**Rezoning Transportation Analysis**  
**Petition Number: Insert Zoning Petition #2021-161**  
*General Location Identifier: 22902119*

Revision Log:	Date	Description
	08-20-2021	First Review (WB)
	09-17-2021	Second Review (WB)
	10-18-2021	Second Review (WB)
	11-22-2021	Fourth Review (AO)

**Rezoning Transportation Analysis**  
**Petition Number: Insert Zoning Petition #2021-161**  
*General Location Identifier: 22902119*

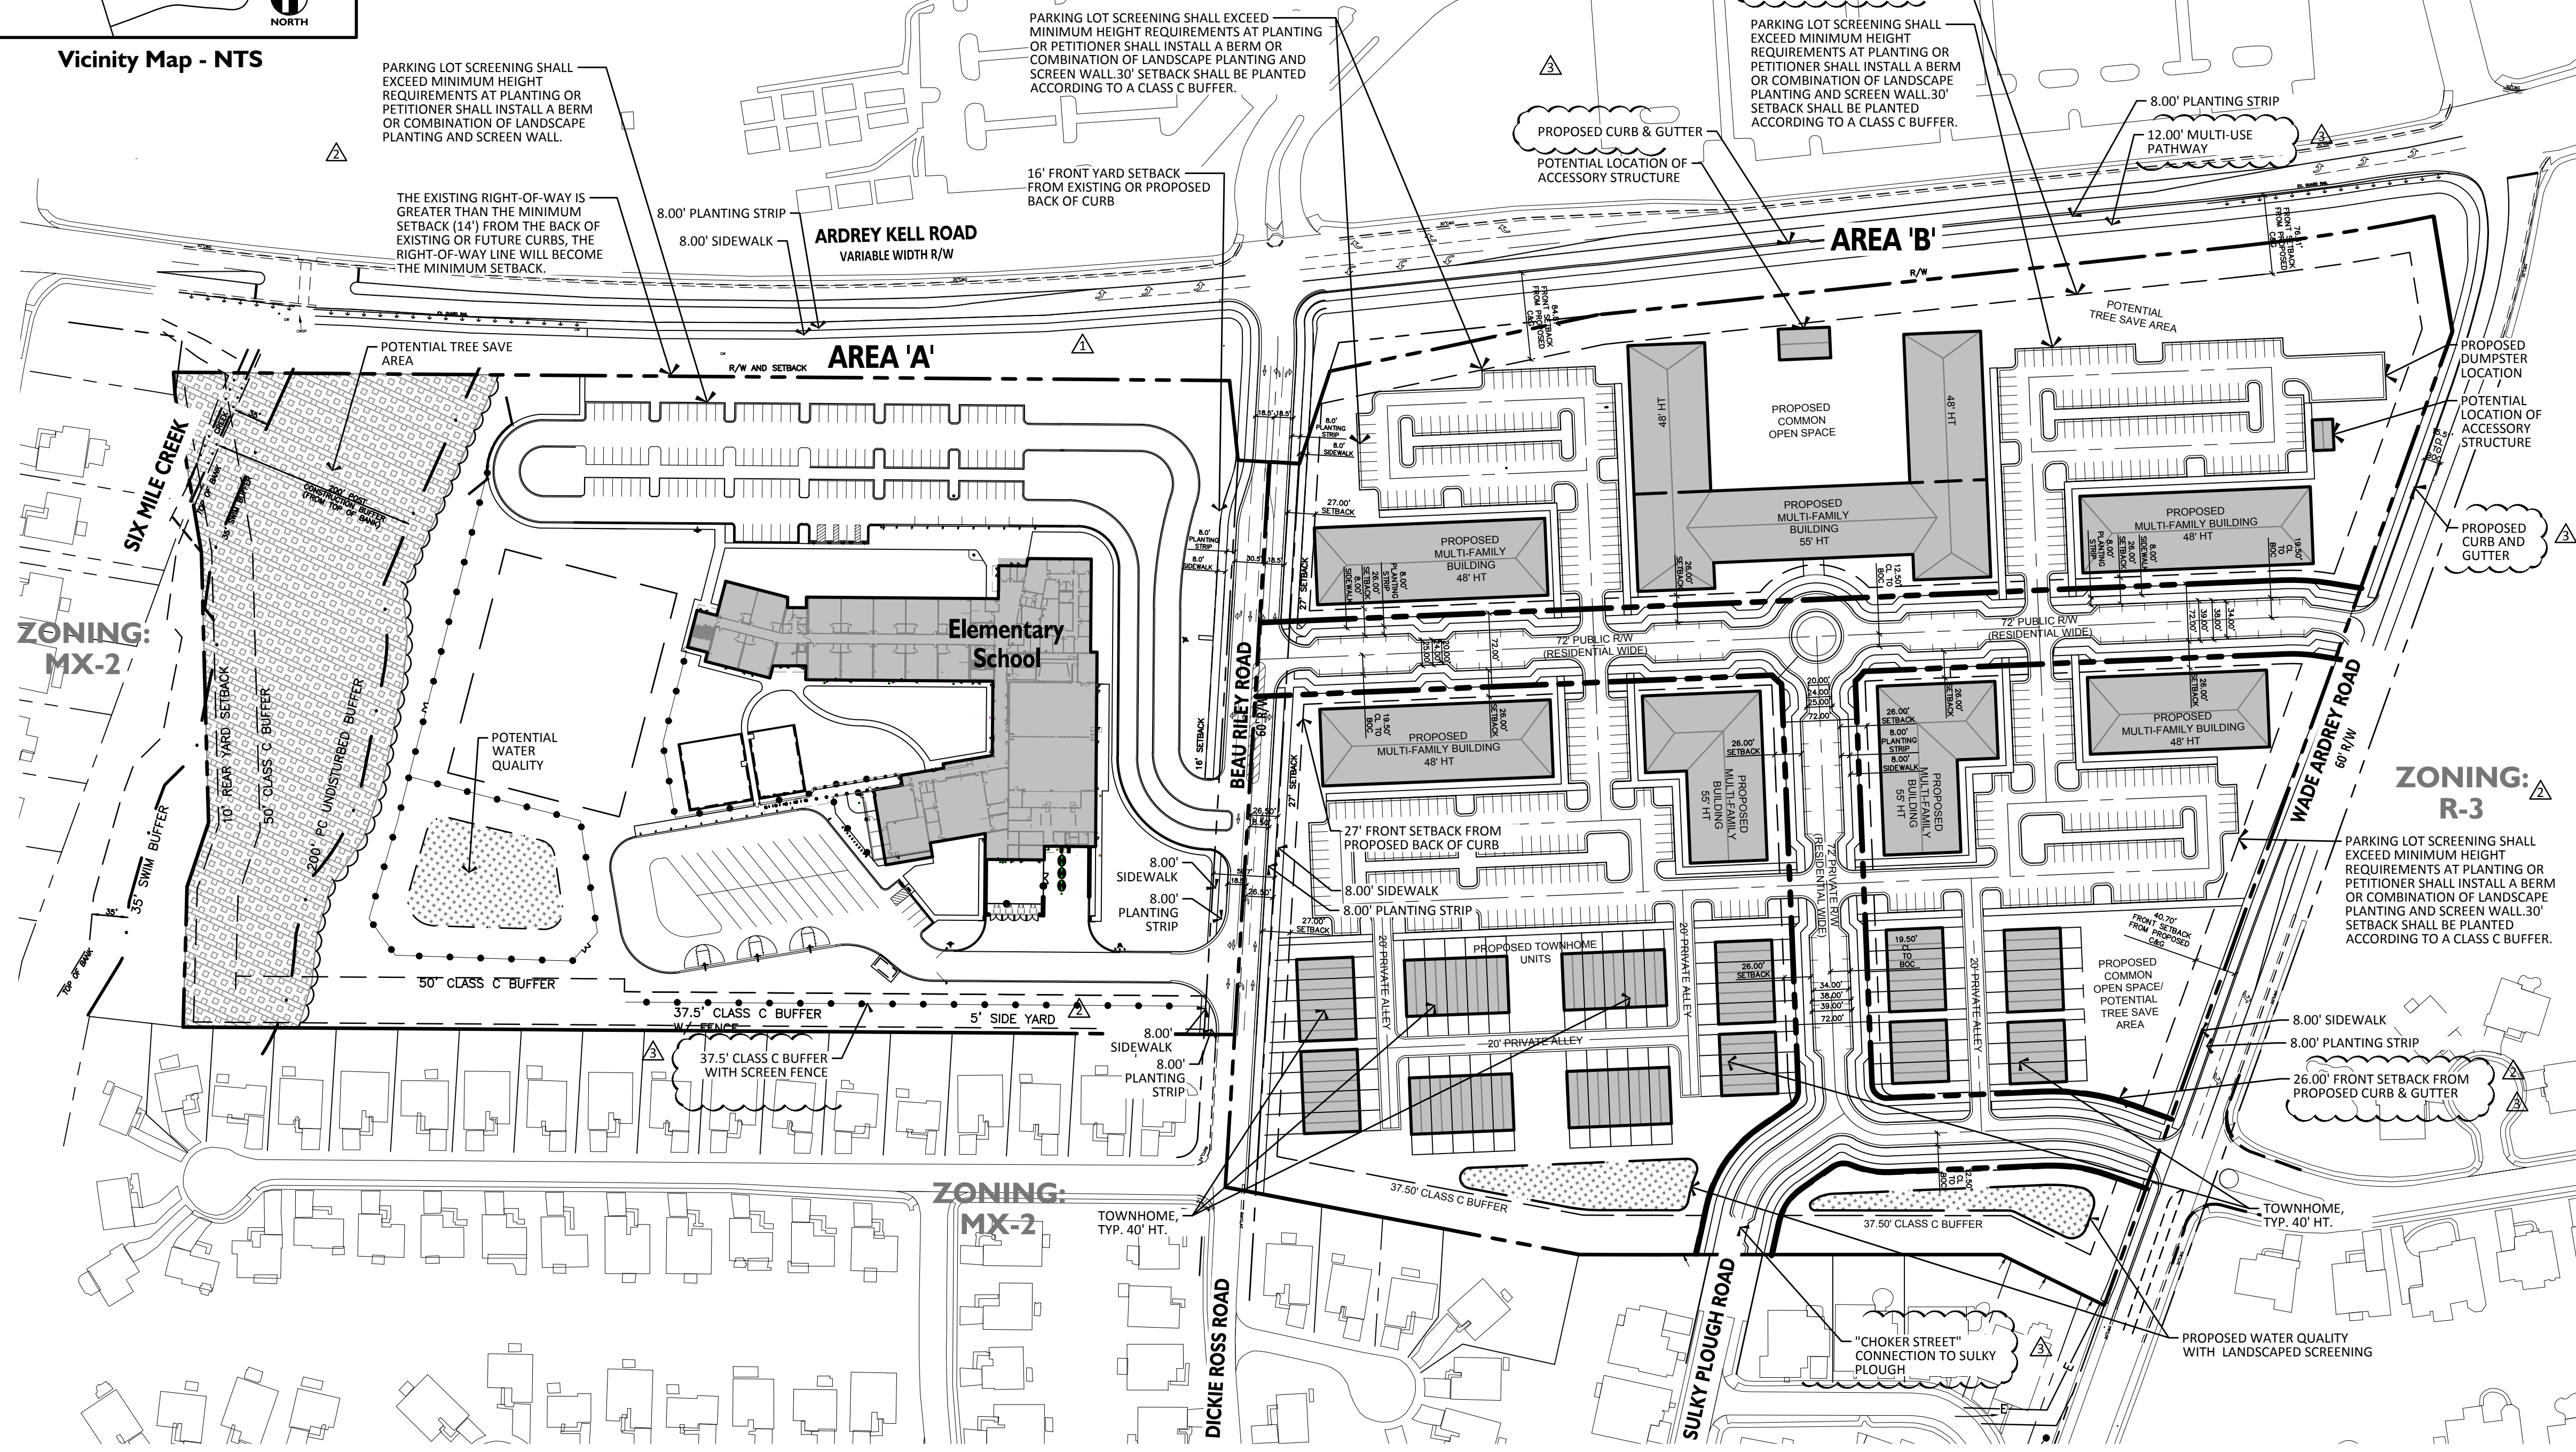
**Update to Comment from 10/18/21:** (site plan dated 11-15-2021): Charlotte BIKES policy requires bikes to be accommodated along Ardrey Kell Road. Provide a 12' Multi-Use path along entire frontage on Ardrey Kell Rd.
